DRB Application No.: <u>07DRB-70063 (P&F)</u>	Project # <u>1005334</u>
Project Name: <u>MESA GRANDE ADDITION</u>	
Agent: <u>Surveys Southwest LTD</u>	Phone No: <u>998-0303</u>

5. Project# 1005334
07DRB-70062 VACATION OF PUBLIC RIGHT-OF-WAY

07DRB-70063 MINOR - PRELIMINARY/ FINAL PLAT APPROVAL

CITY OF ALBUQUERQUE
PLANNING DEPARTMENT
DEVELOPMENT REVIEW BOARD

PLAT OF
 LOT 1-A, BLOCK 13
 MESA GRANDE ADDITION
 SECTION 23, T. 10 N., R. 3 E., N.M.P.M.
 CITY OF ALBUQUERQUE
 BERNALILLO COUNTY, NEW MEXICO
 JUNE 2007
 SHEET 2 OF 2

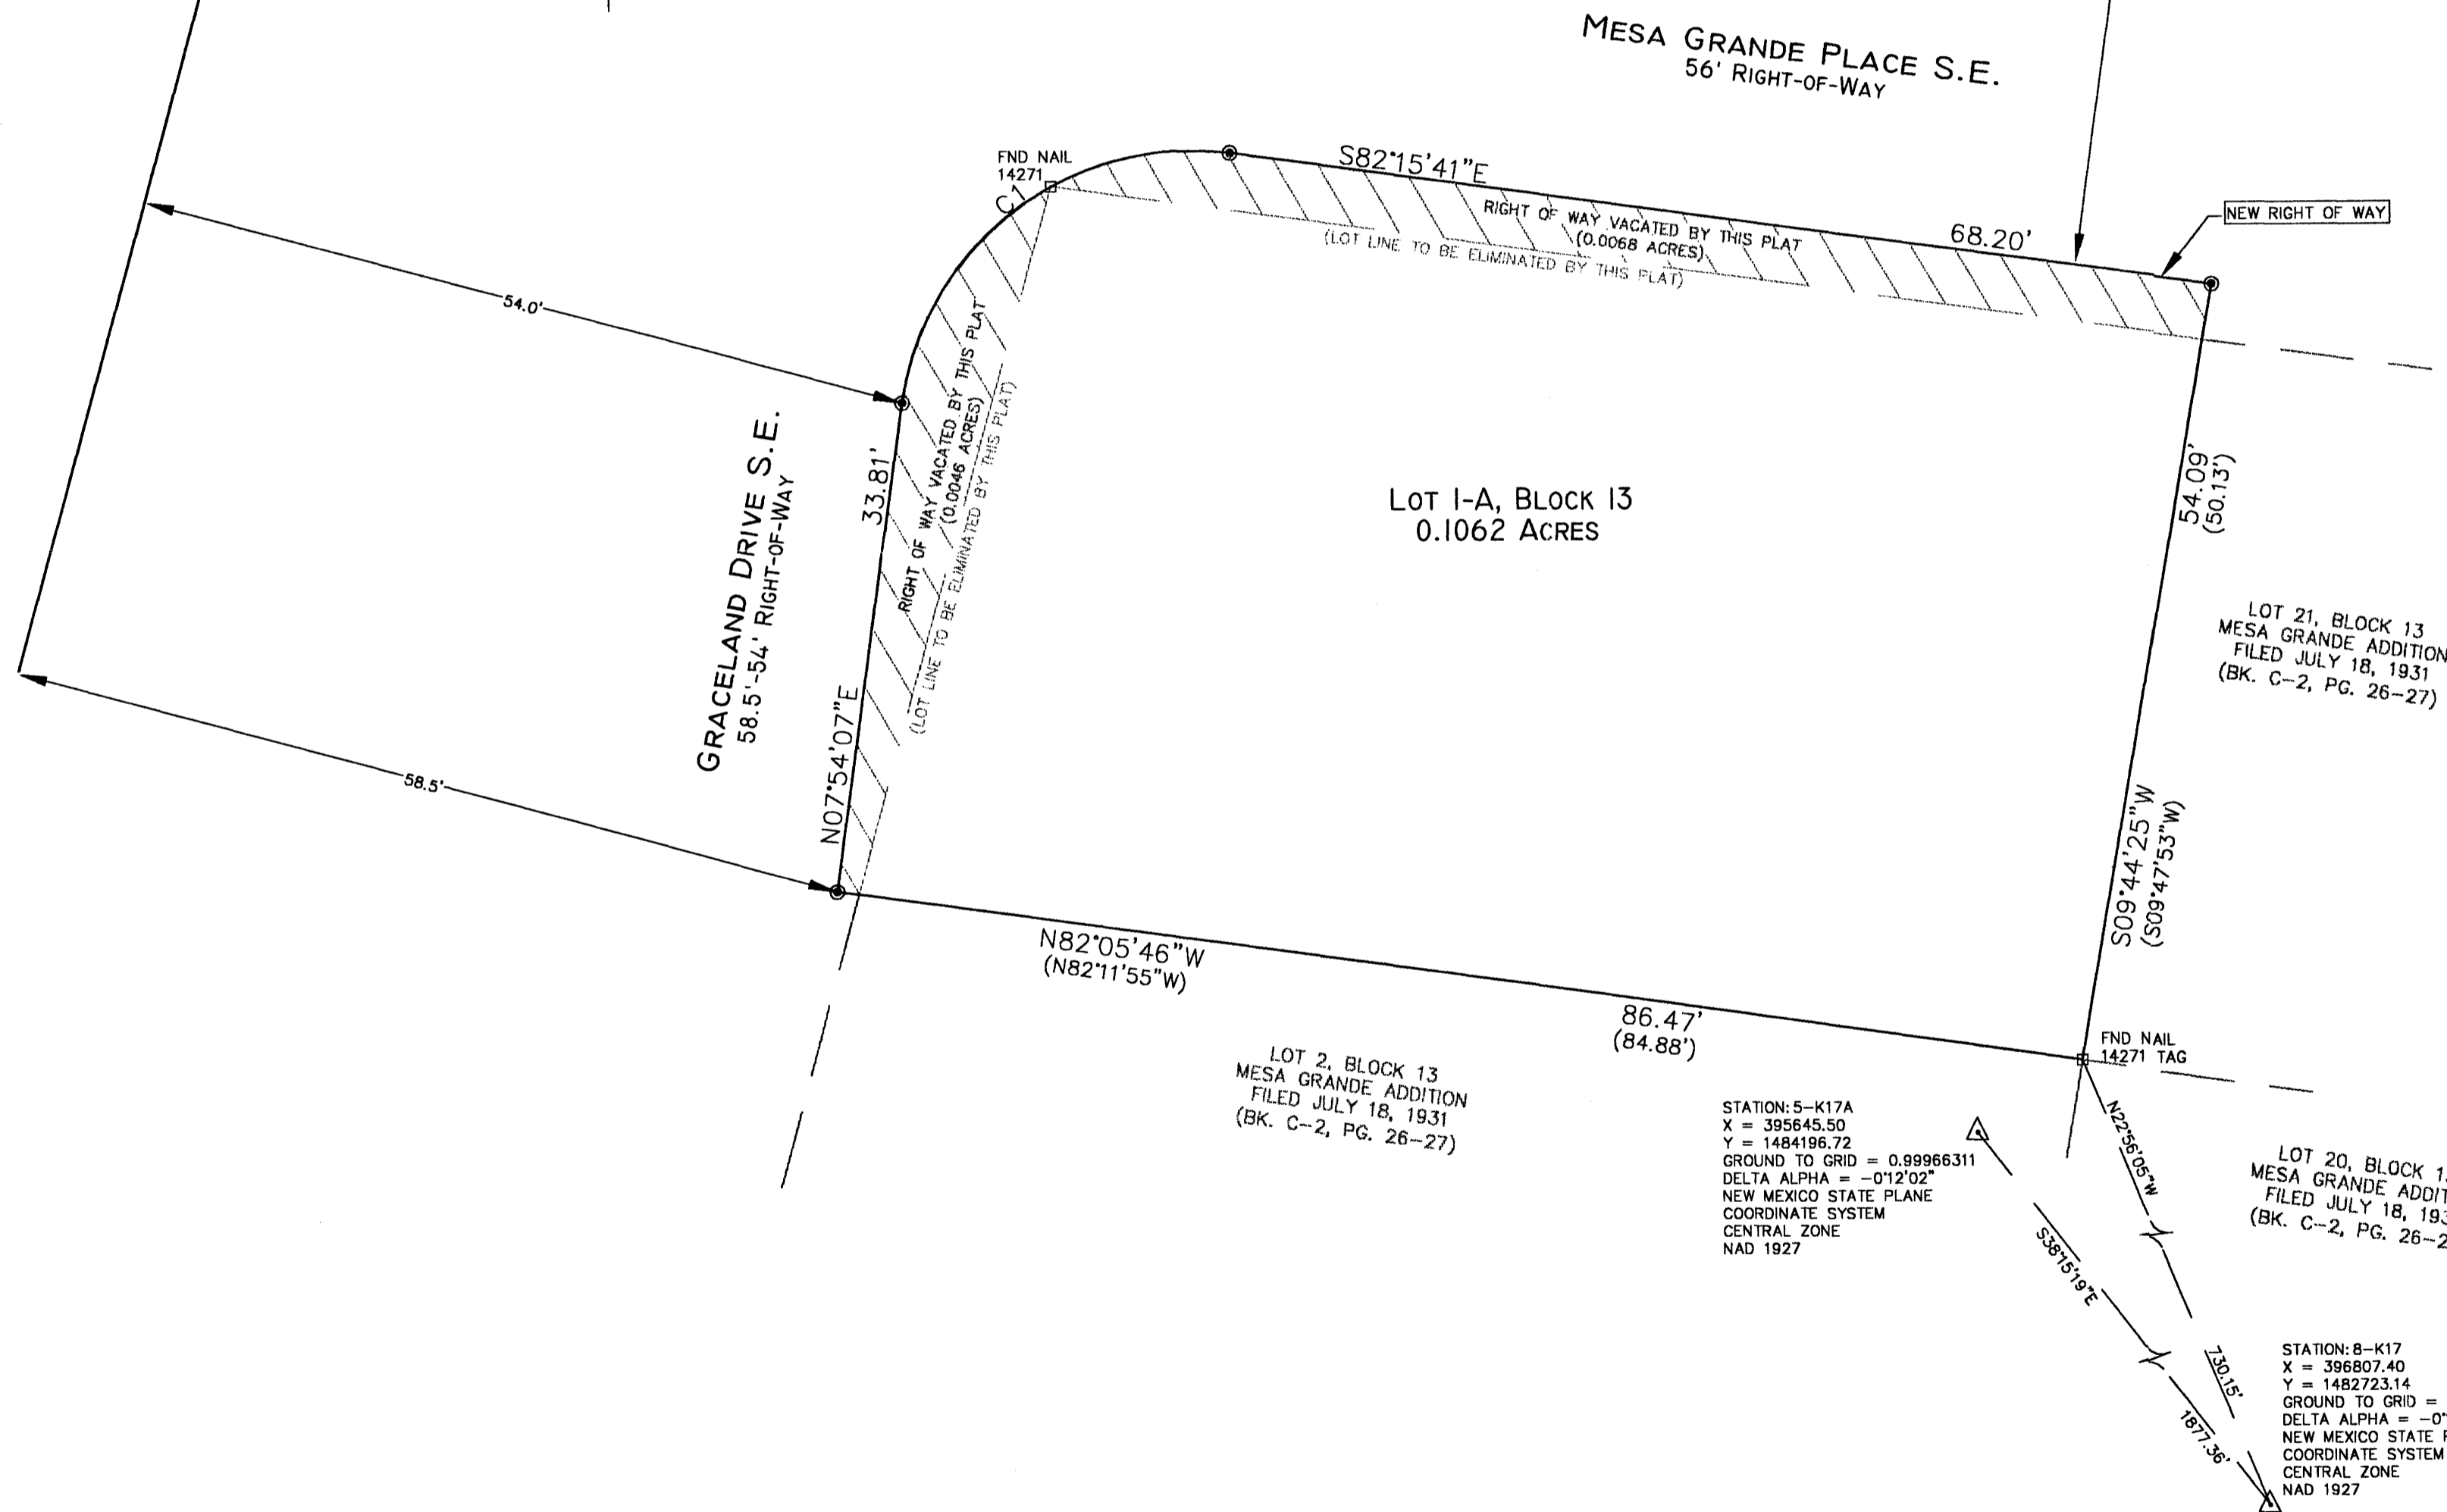
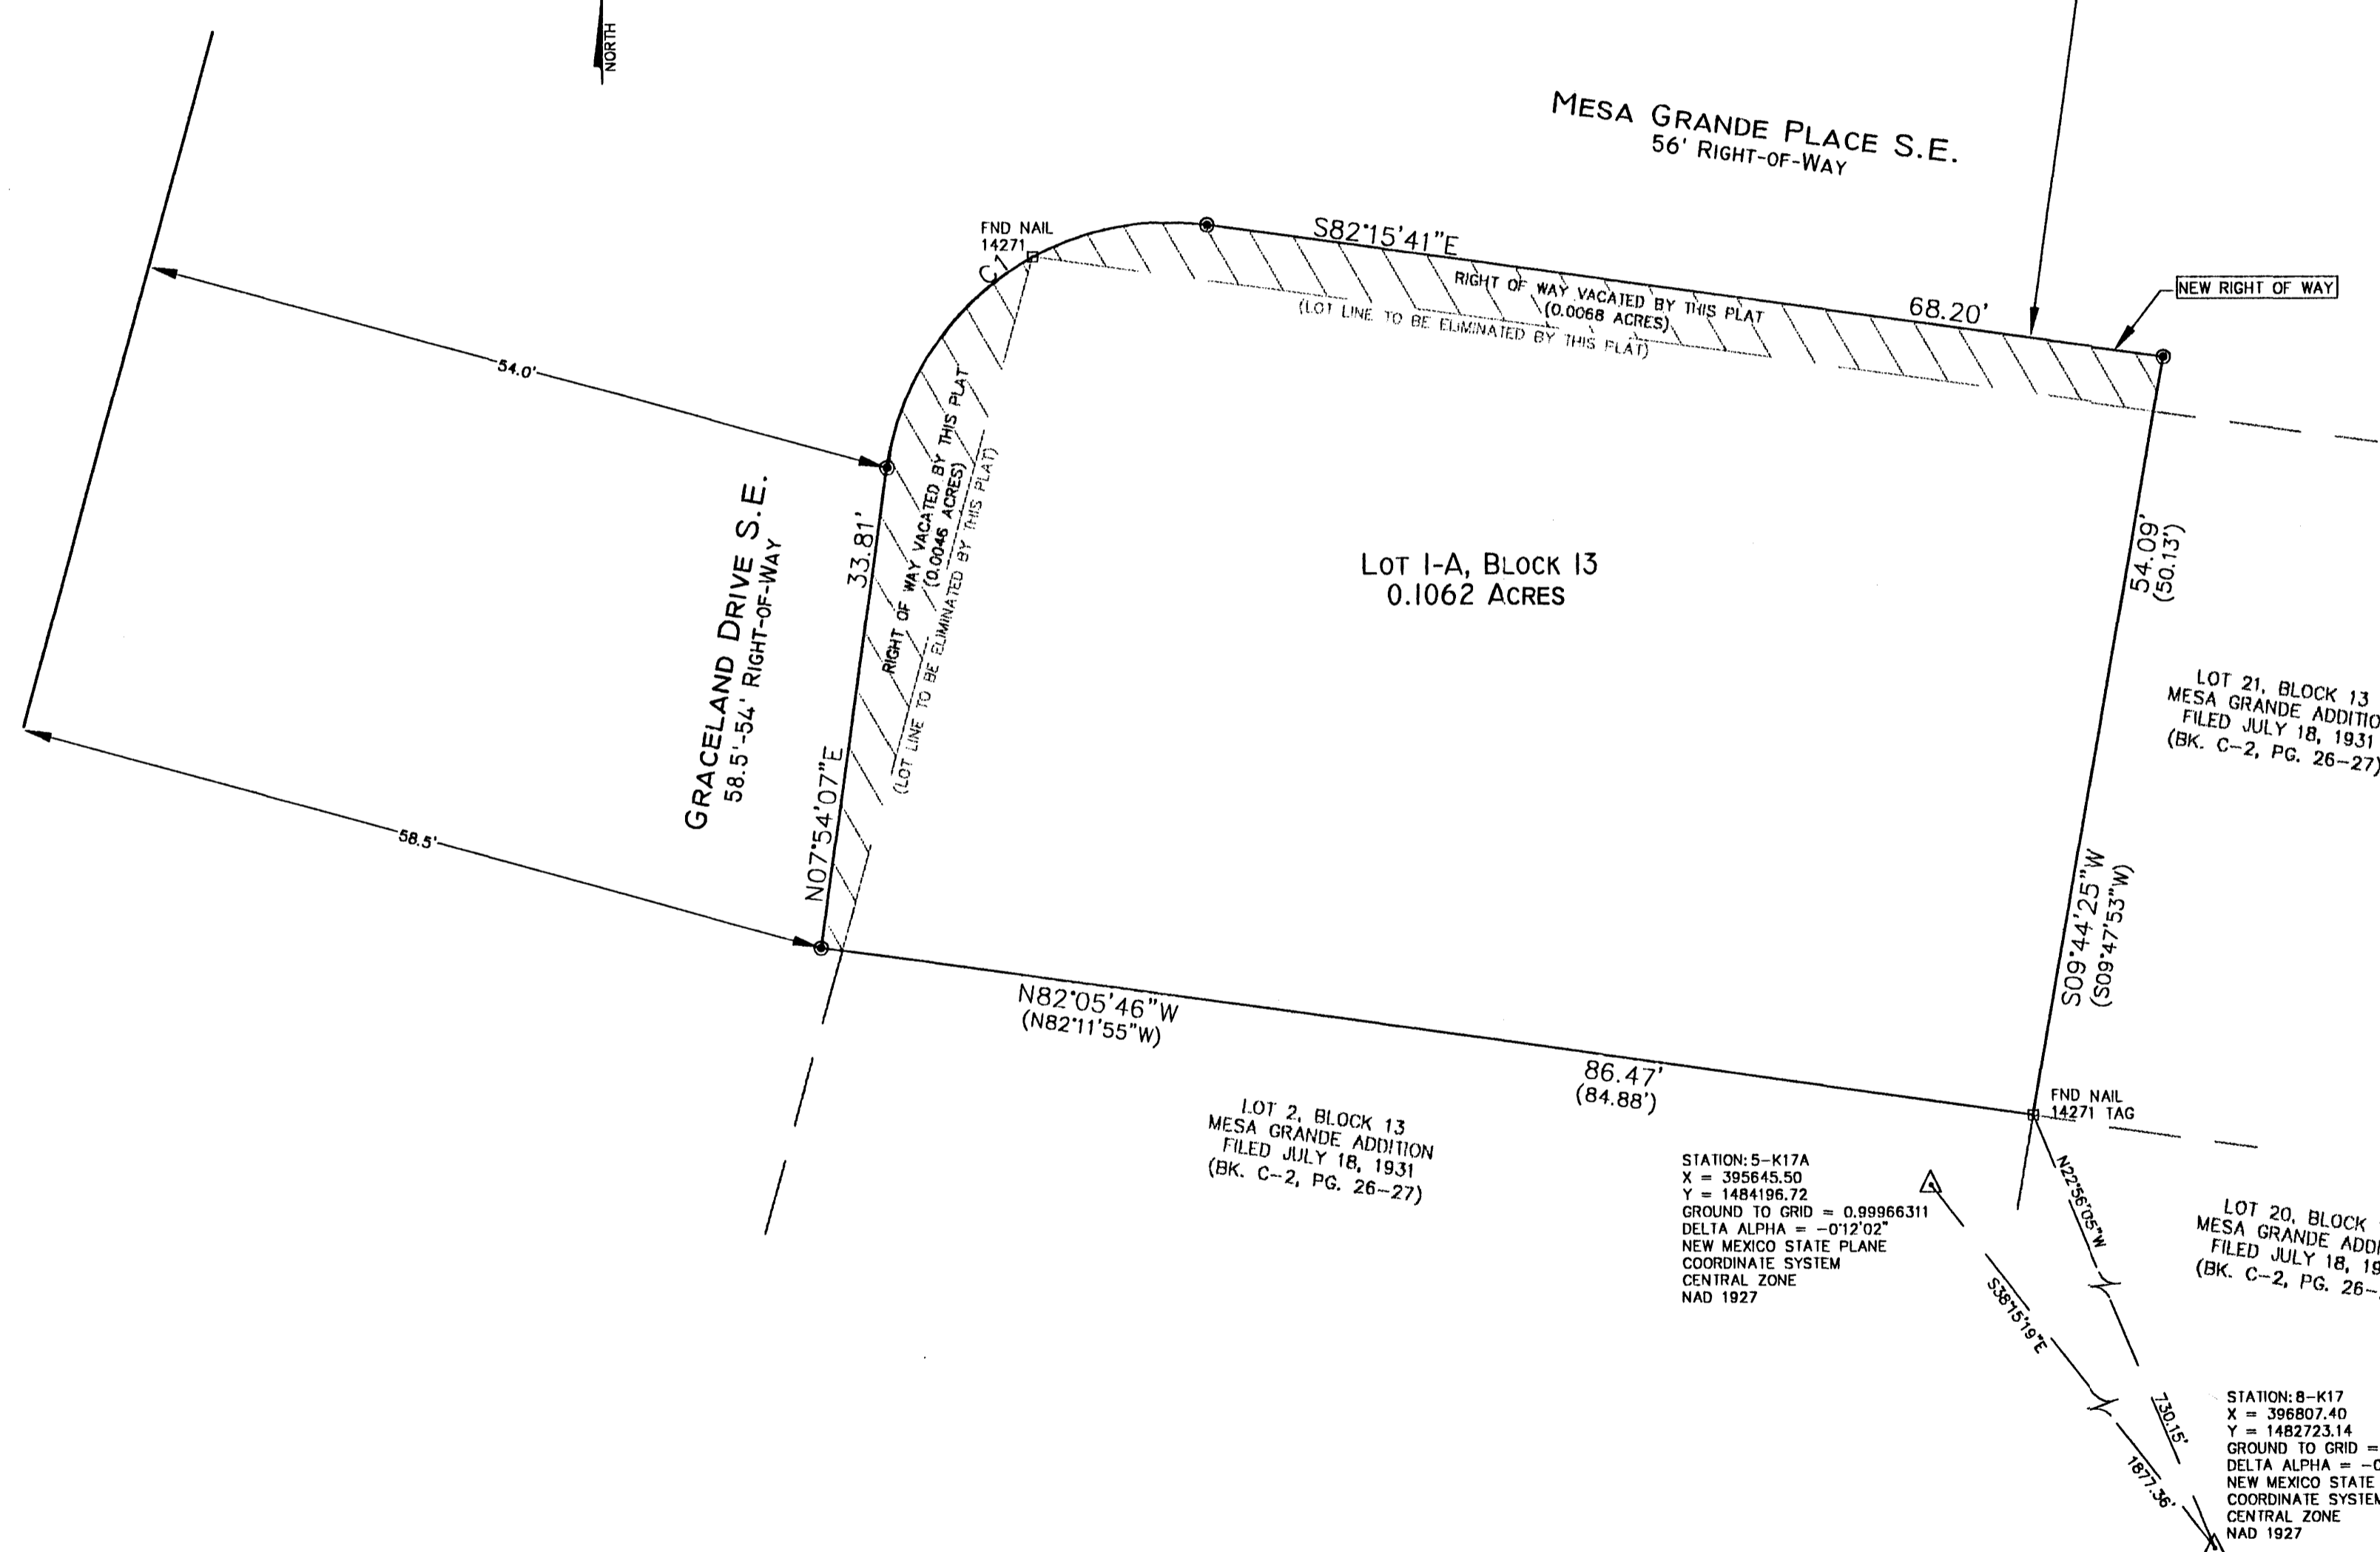
City Engineer An approved drainage report is required for Preliminary Plat approval.

Has the corner of the apartment been demolished? If so, transportation will have no objection to either request.
